To: Shahab Biazar, P.E.
Development and Building Services
City of Albuquerque

From: Daniel S. Aguirre, P.E.

Date: October 24, 2011

Re: Volcano Heights Drainage Compilation Report

VOLCANO HEIGHTS
 CONCEPTUAL DRAINAGE COMPILATION PLAN

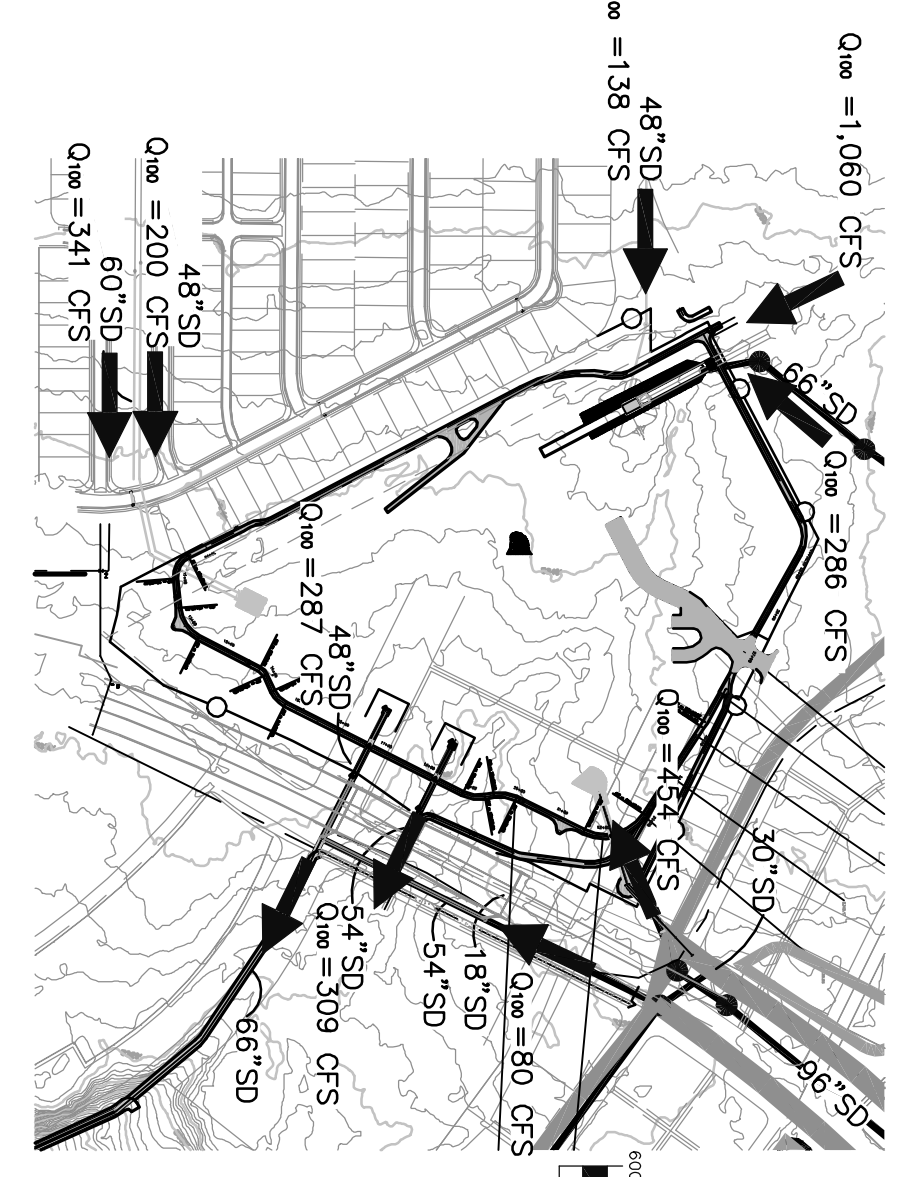
6. **Flow numbers for Basins K2, M5, M6, and T1 are not the same on the Plate-1, Table-1/Plate-1 and AHYMO calculations. T1 basin area is different from the AHYMO calculations and what is shown on the Plate-1.** All numbers corrected.
